REPORT UPDATE

Application No: AW/71/18/HH

LOCATION: 36 Kingsway
Aldwick
PO21 4DH

PROPOSAL: Demolition of existing ground floor extensions to front of property, construction of a single storey rear extension & reworking of existing external hard & soft landscaping including new vehicular access onto Kingsway. This application affects the character & appearance of the Craigweil House Conservation Area.

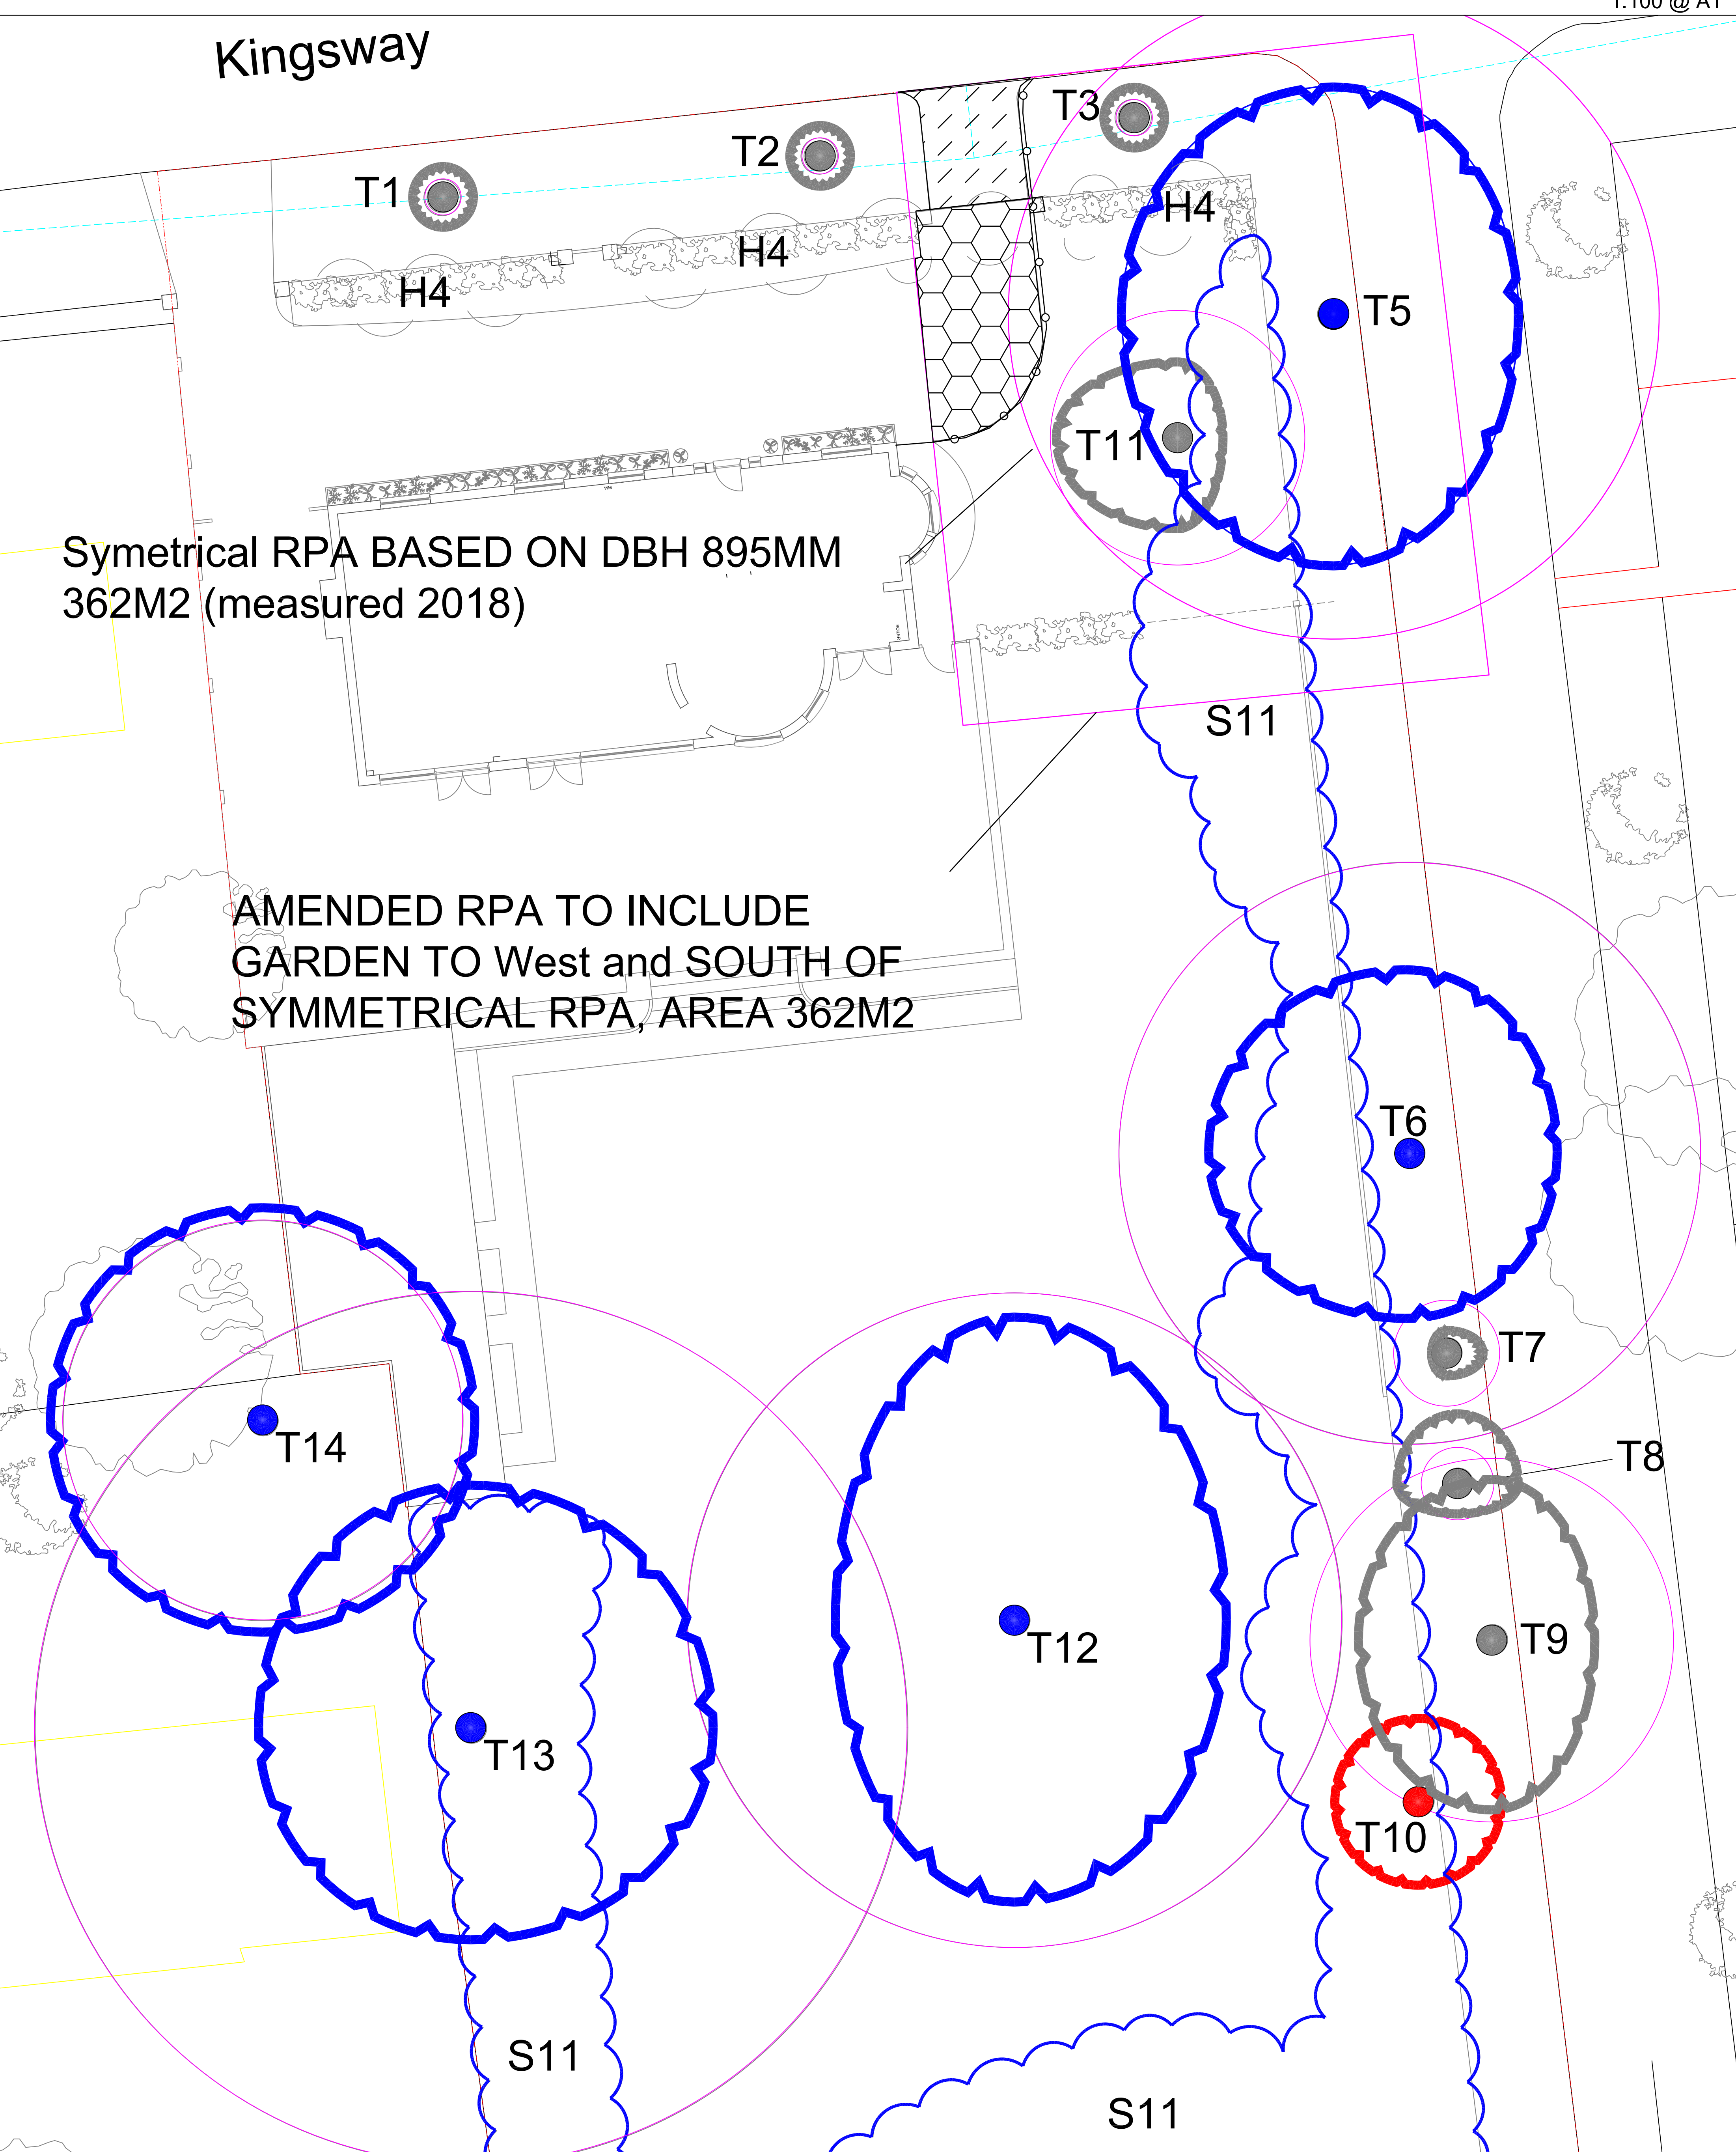
The Council's Tree Officer provided additional comment on the 30th July and this is summarised below:

- The Tree Officer had not previously considered the impact of the new gate pillars on the RPA of T5;
- Excavation to facilitate construction of the eastern pillar will occur within the amended RPA;
- Therefore, the Arboricultural Method Statement needs to refer to methodology and the inclusion of soil/root protection measure to limit the effects on tree health;
- There will be a risk of harmful soil contamination if as expected concrete is used to form an adequate footing for the pillar; and
- It is recommended that the following addition be sought to the Arboricultural Method Statement:

"The excavation for and construction of; footings for the eastern pillar (driveway access) within the RPA of T5, will be undertaken with care so as to avoid unnecessary damage to tree roots. Only hand-digging is permitted, and of sufficient depth and width so far as is necessary. Leachate from curing concrete can be toxic to tree roots therefore all pits are to be lined with impervious membrane before pouring concrete."

In response to this, the applicant submitted a revised Arboricultural Method Statement on the 31st July and this includes the additional paragraph. It is therefore necessary to amend condition 03 to refer to the Rev D Arboricultural Method Statement.

Proposed section through new driveway

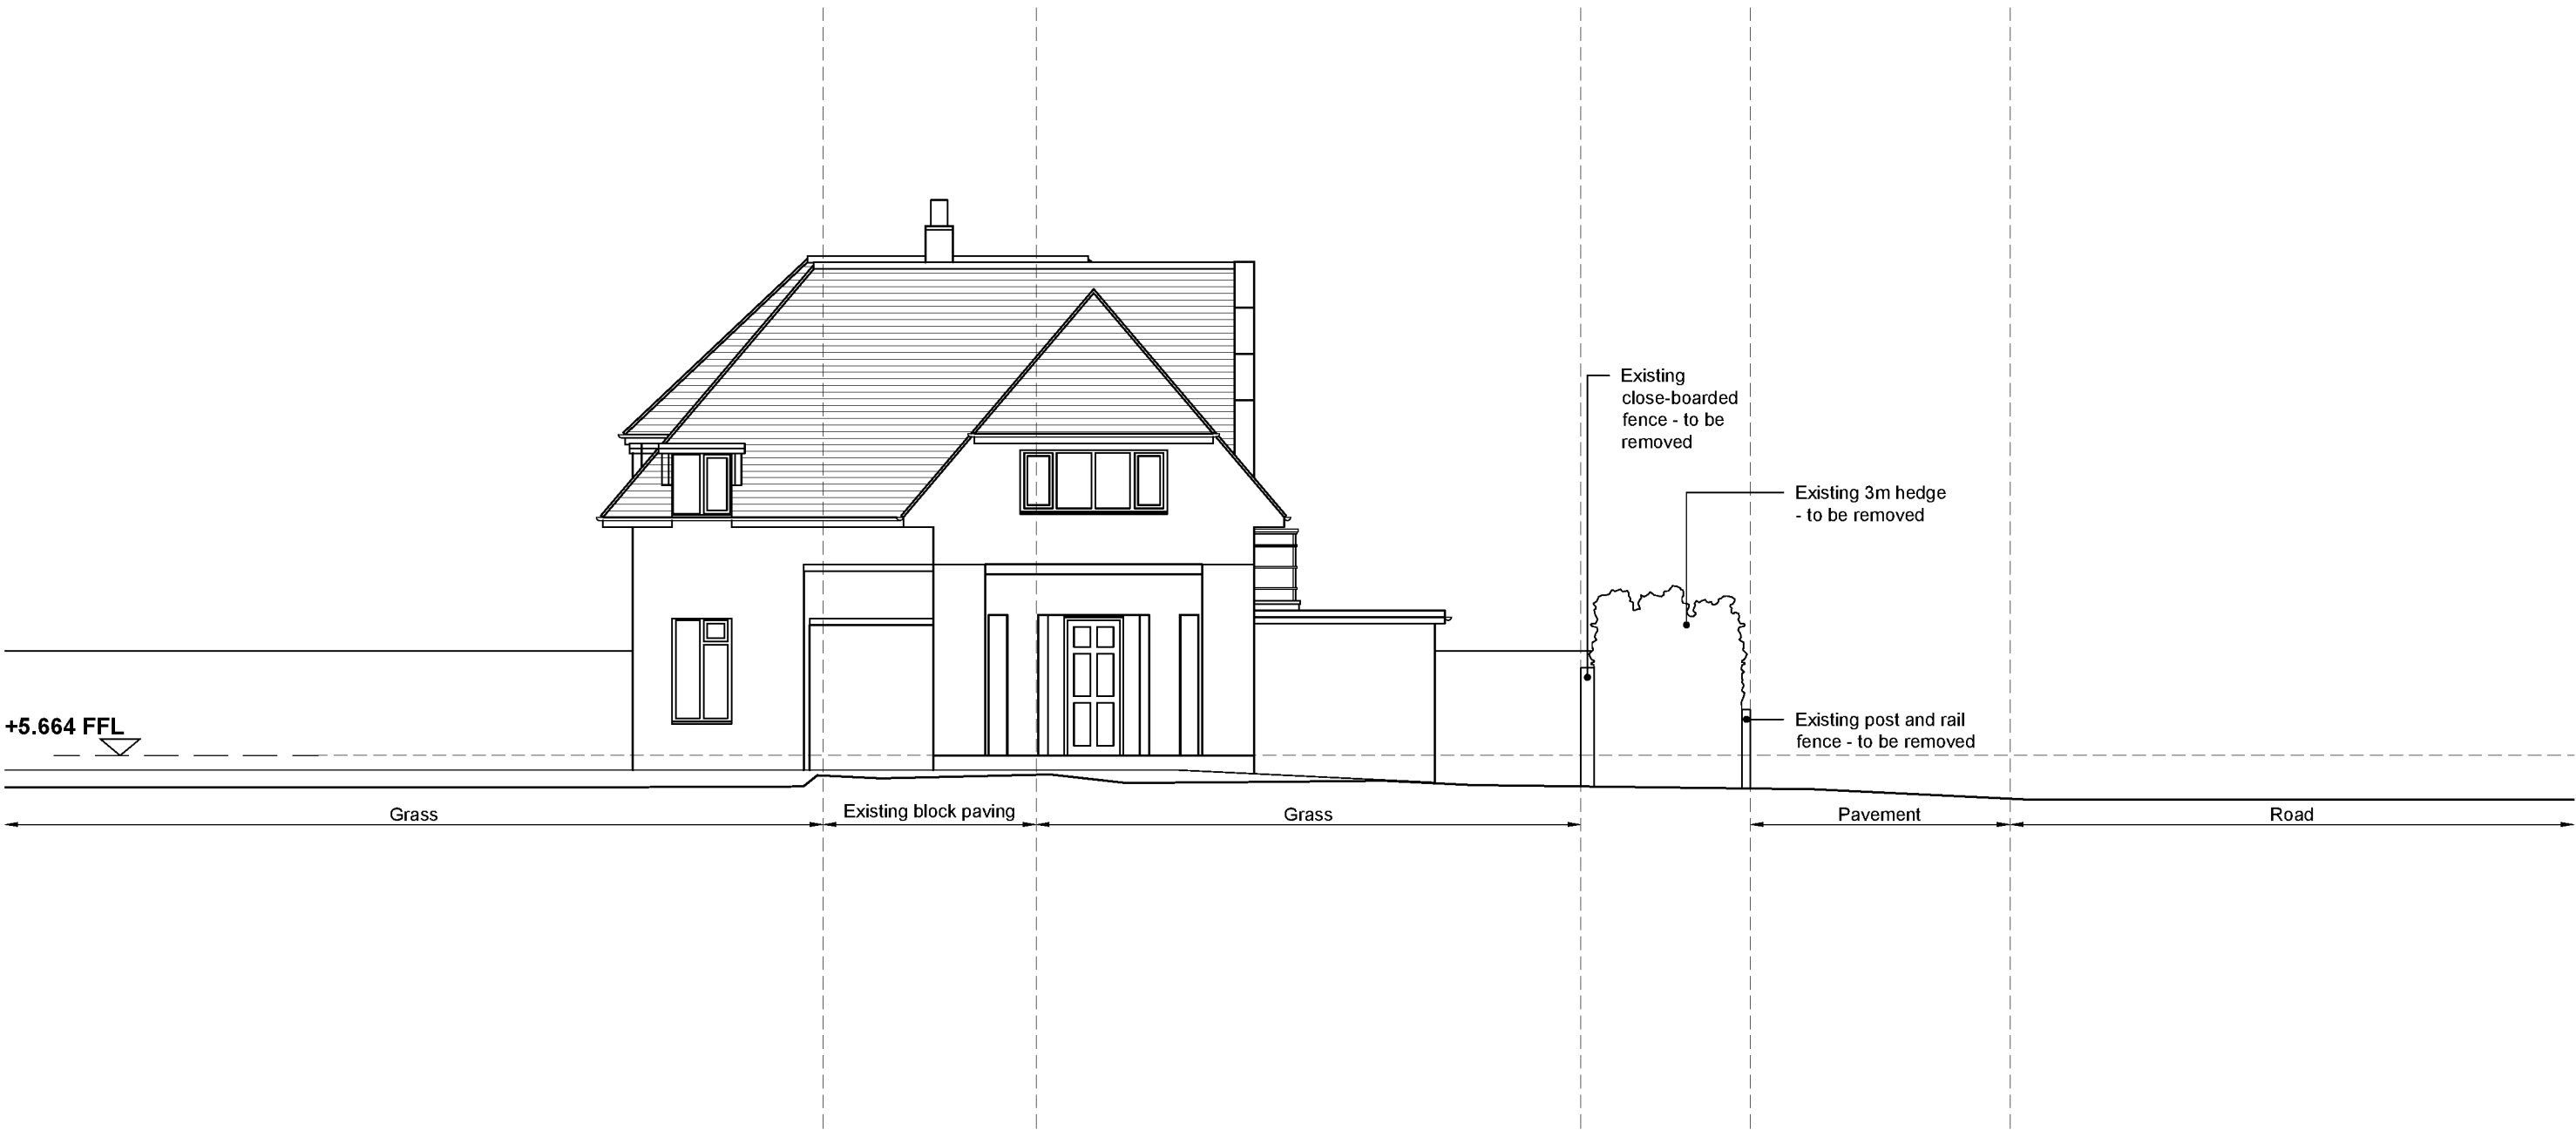
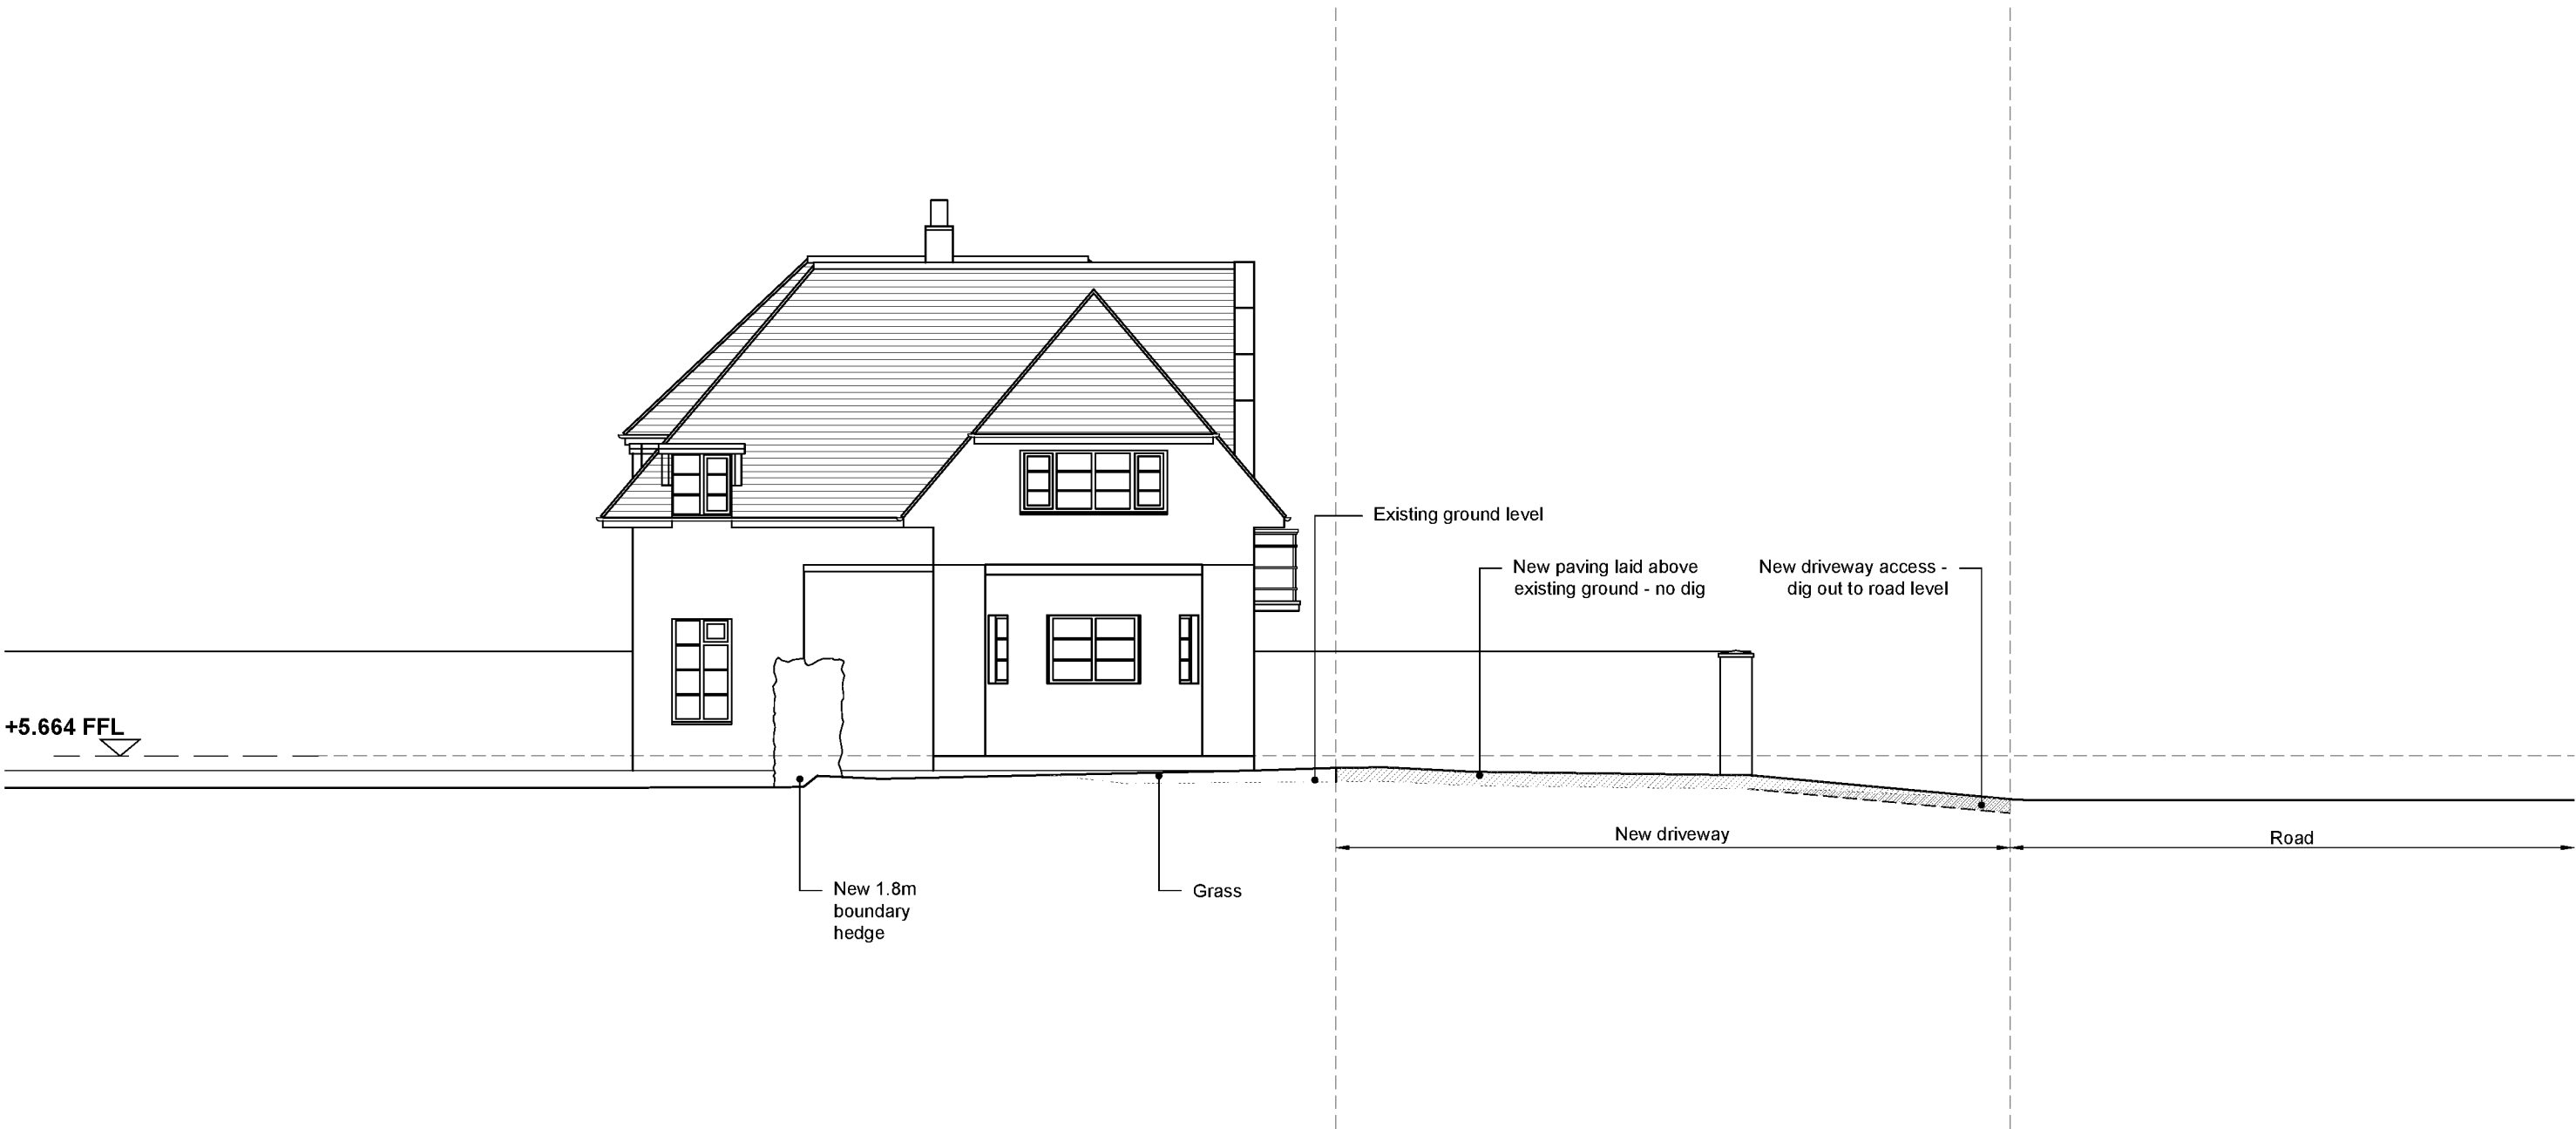
A local resident had commented that a ramped access from the road would detract from the streetscene.

However, we are unable to give examples of other ramped accesses within the Craigweil Estate.

There are existing and proposed section drawings within the Tree Survey report which illustrate that there will be a slightly greater gradient on the slope between the site and the road.
